East Anglia ONE North and East Anglia TWO Offshore Windfarms

Applicants' Comments on SASES' Deadline 4 Submissions

Applicant: East Anglia TWO and East Anglia ONE North Limited
Document Reference: ExA.AS-9.D5.V1
SPR Reference: EA1N_EA2-DWF-ENV-REP-IBR-001223

Date: 3rd February 2021
Revision: Version 01
Author: Royal HaskoningDHV

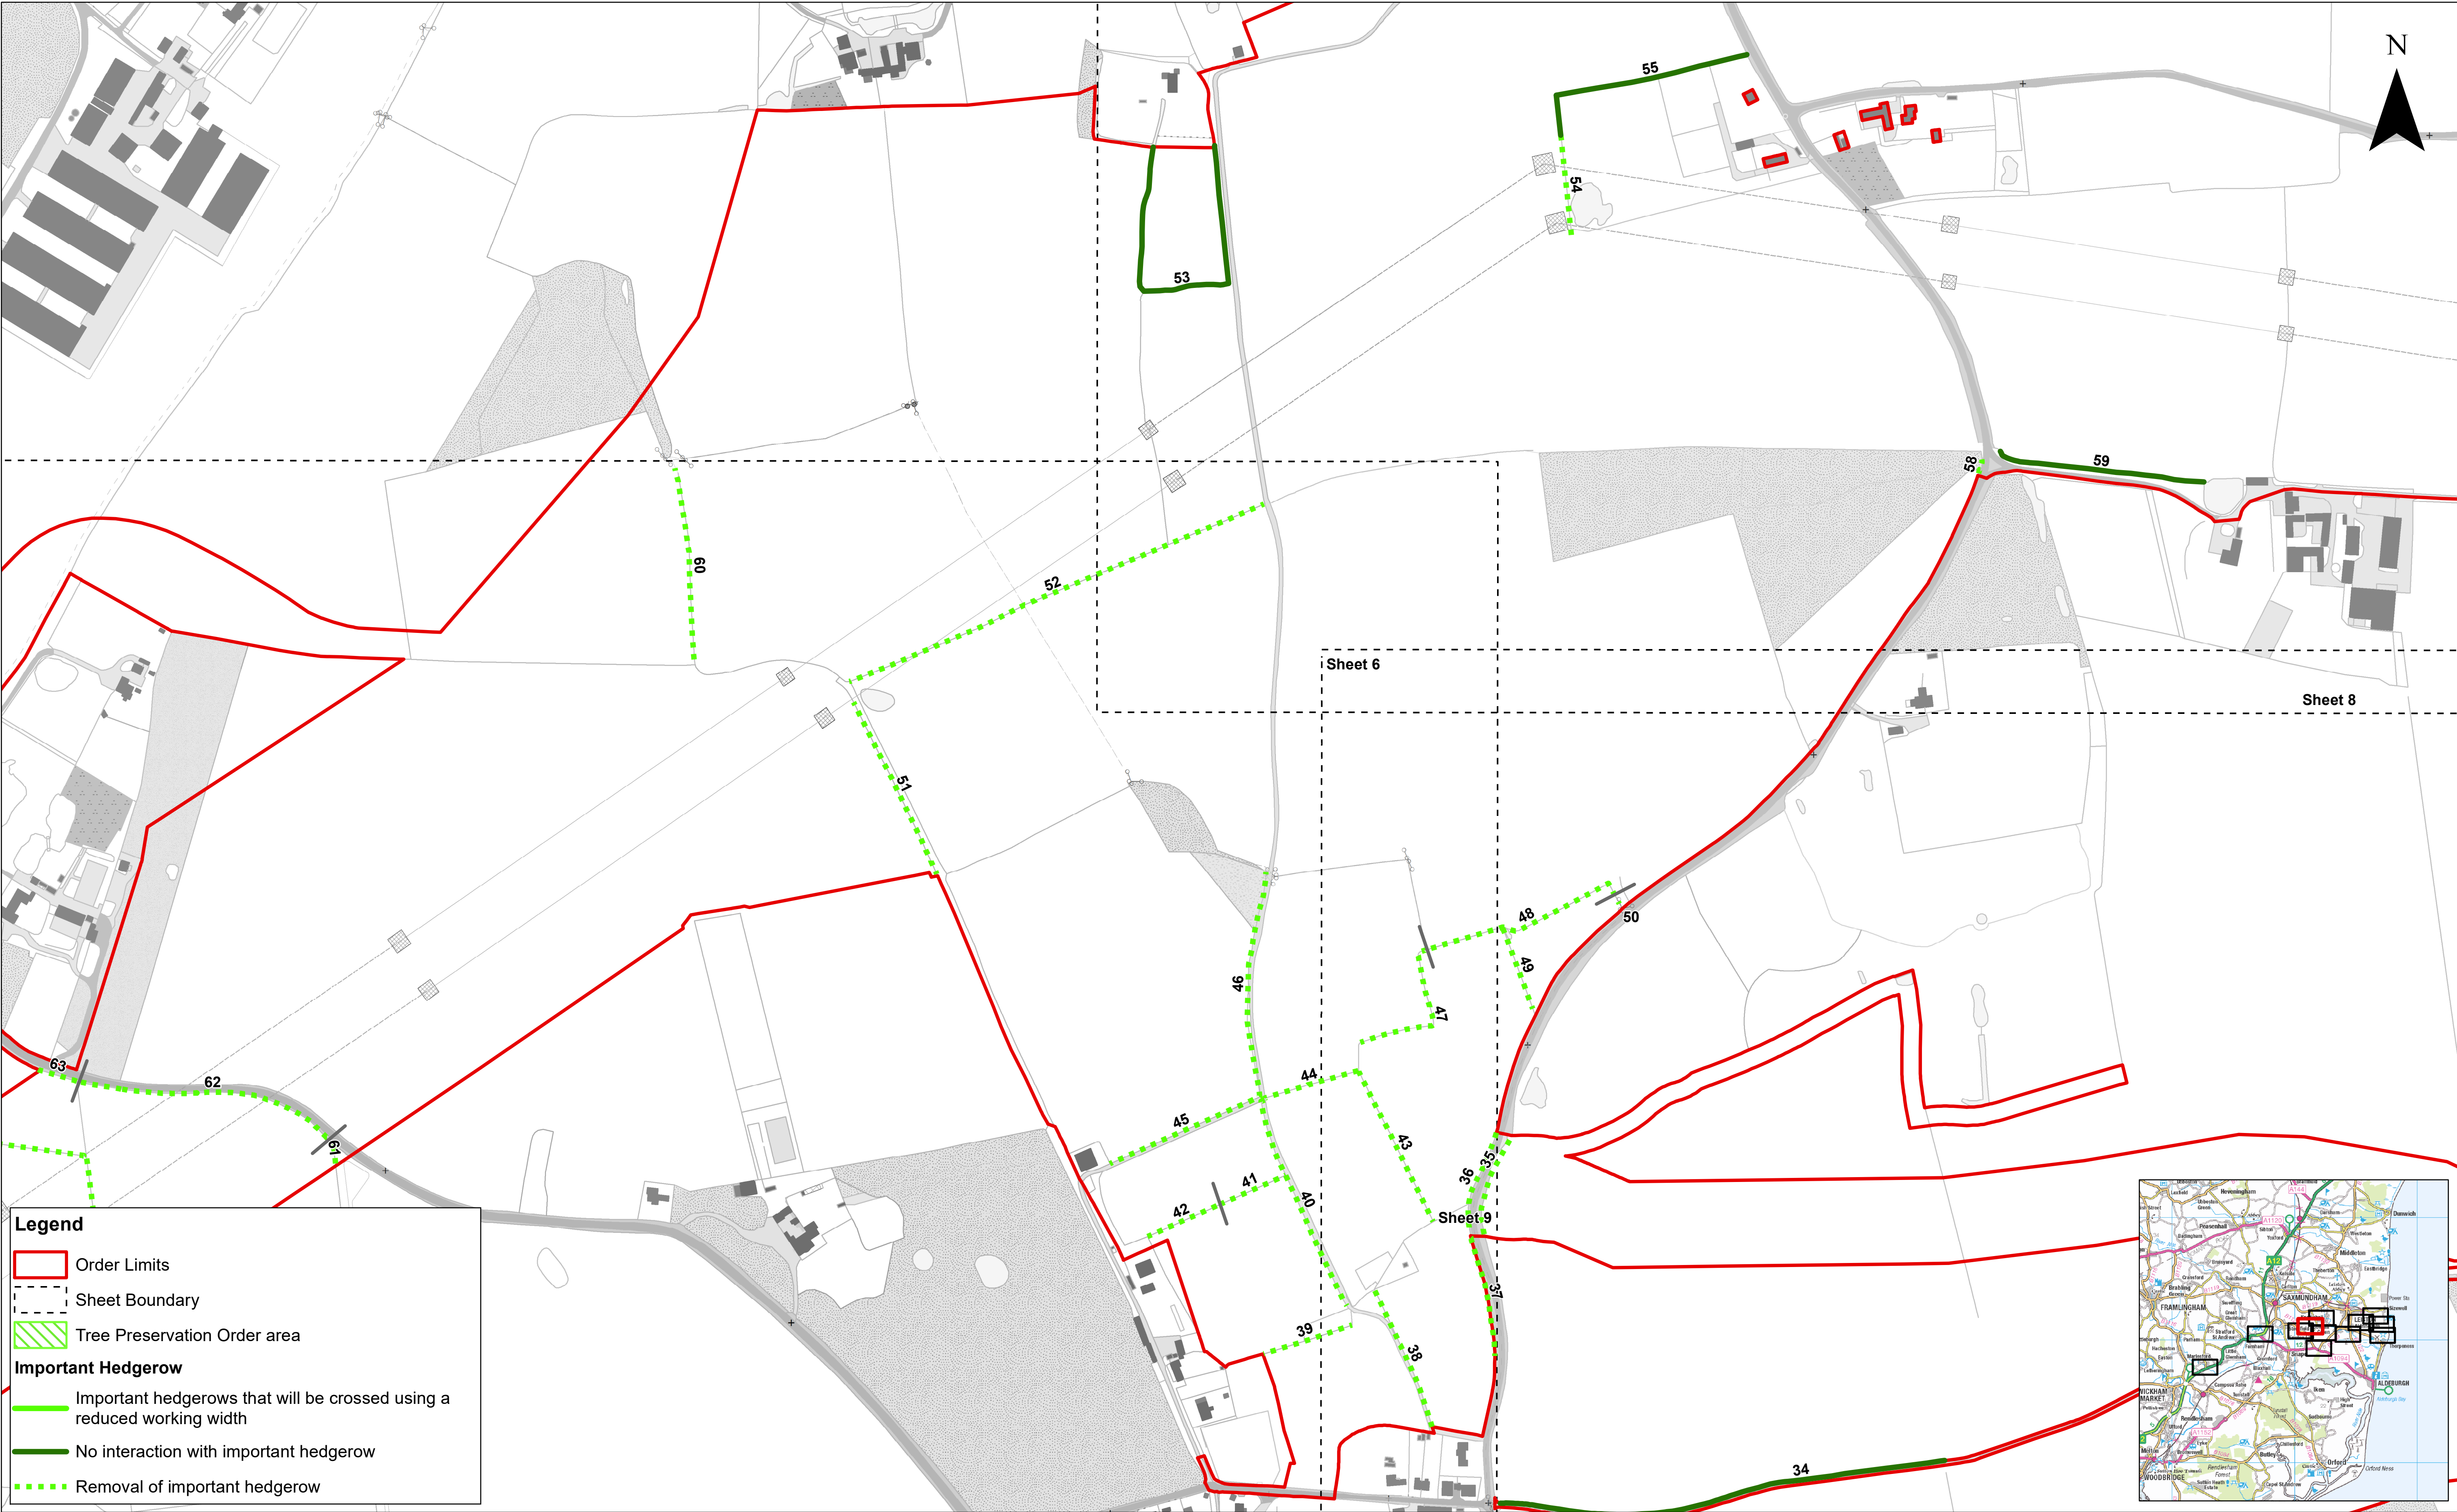
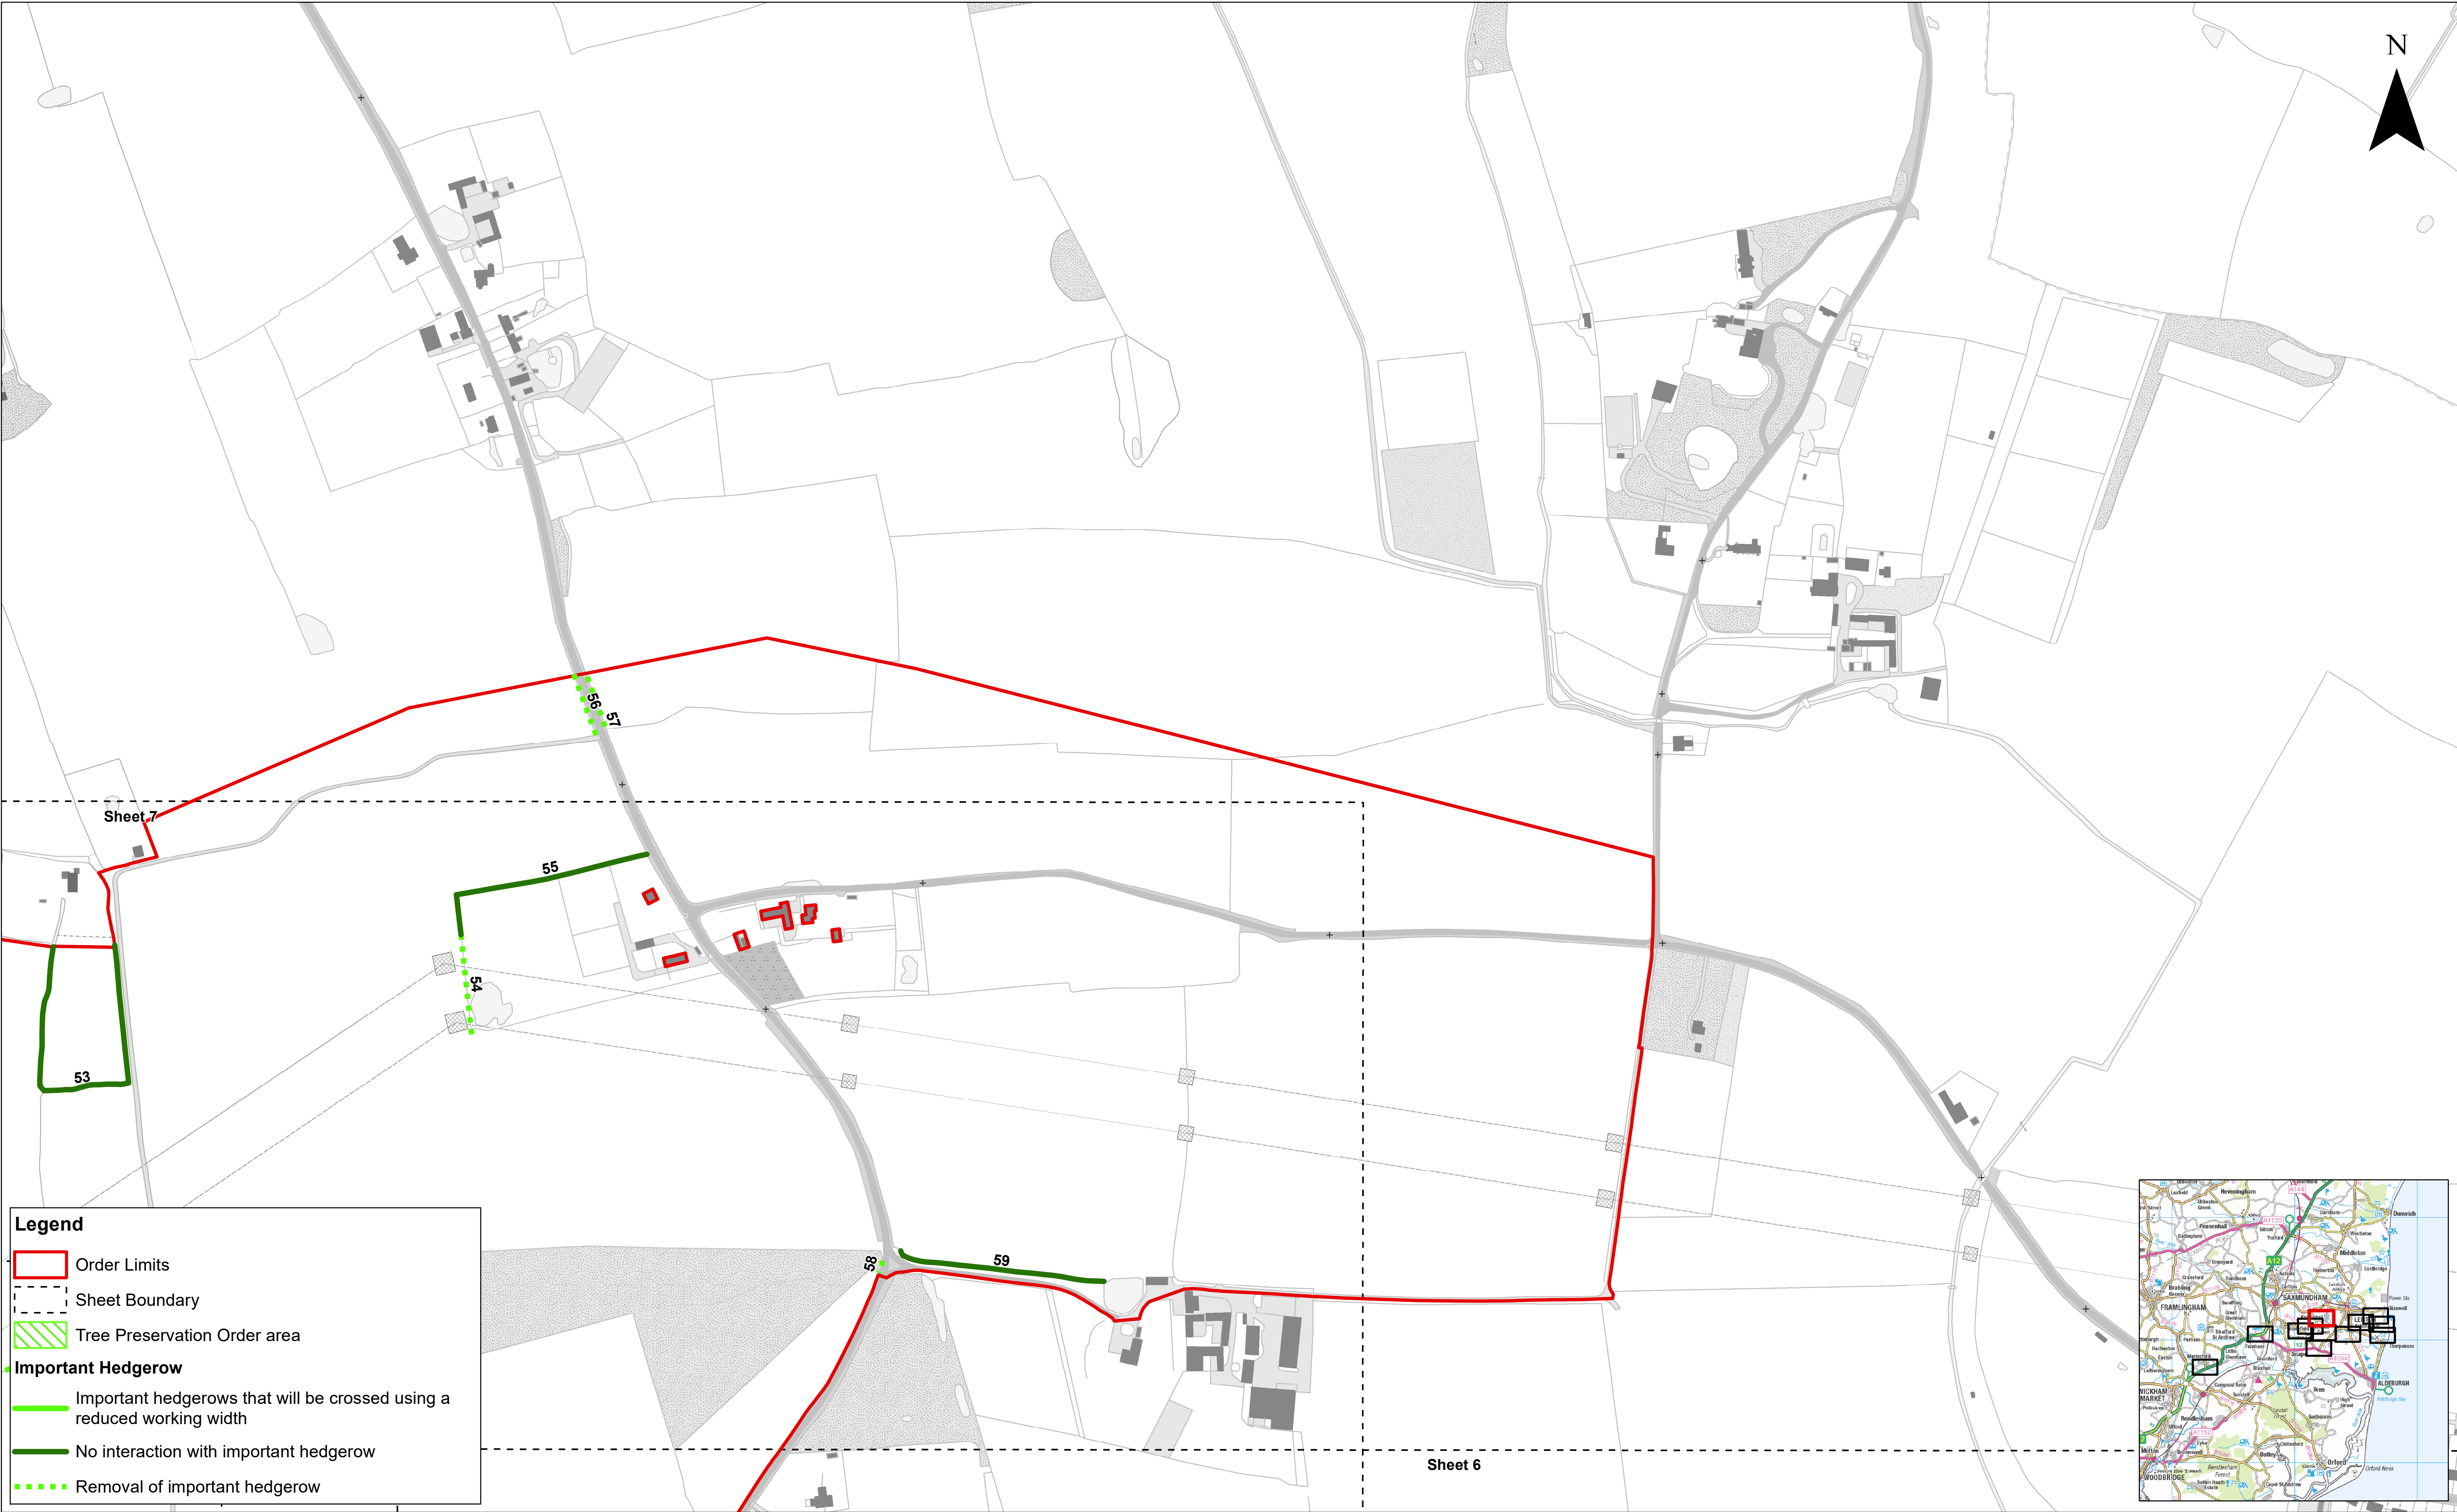
9	38. Annex 1: Hedgerows Schedule – The Applicant is asked to explain what is meant by "Landscape Mitigation" in respect of Hedgerows 38 to 50 as these are shown for removal on Sheet 7 of the Important Hedgerows and Tree Preservation Order Plan.	<p>It is noted that the draft DCO (REP3-011) and accompanying Important Hedgerows and Tree Preservation Order Plan (REP3-010) provide the rights to remove all or part of the specified hedgerows. However, any works to hedgerows must be undertaken in accordance with the final landscape management plan. The final landscape management plan must accord with the OLEMS (REP3-030) and be submitted to and approved by the relevant planning authority prior to the commencement of onshore works.</p> <p>In respect of hedgerows 38 – 50, categorised as landscape mitigation within the OLEMS, it is anticipated that only small sections may require</p>

ID	Written Representation	Applicants' Comments
		removal to facilitate the required construction works and landscaping. The Applicants refer to ID1 within Section 2.3 Onshore Ecology .
10	39. Section 3.5.13 Public Rights of Way - Paragraph 149 – This paragraph has been amended from the proposals that the “permanent diversions will be completed by the end of the construction phase” to “the proposed permanent diversions will be in place prior to the existing PRoW being stopped up”. No explanation is given as to what PRoWs will be available to the public during the construction phase despite the Applicants’ confirmation in their response to SASES Deadline 1 submissions Row 04-07 that it does not intend to keep FP6 open during the construction phase. The omission to explain how the PRoW network on the substation site will function during the construction phase is unacceptable and the Applicant should be asked to clarify the situation fully prior to DCO consent.	For clarity, the Temporary Stopping up of Public Rights of Way Plan (REP3-008) and Outline Public Rights of Way Strategy (REP3-024) provides information on PRoW available to the public during construction of the Projects.
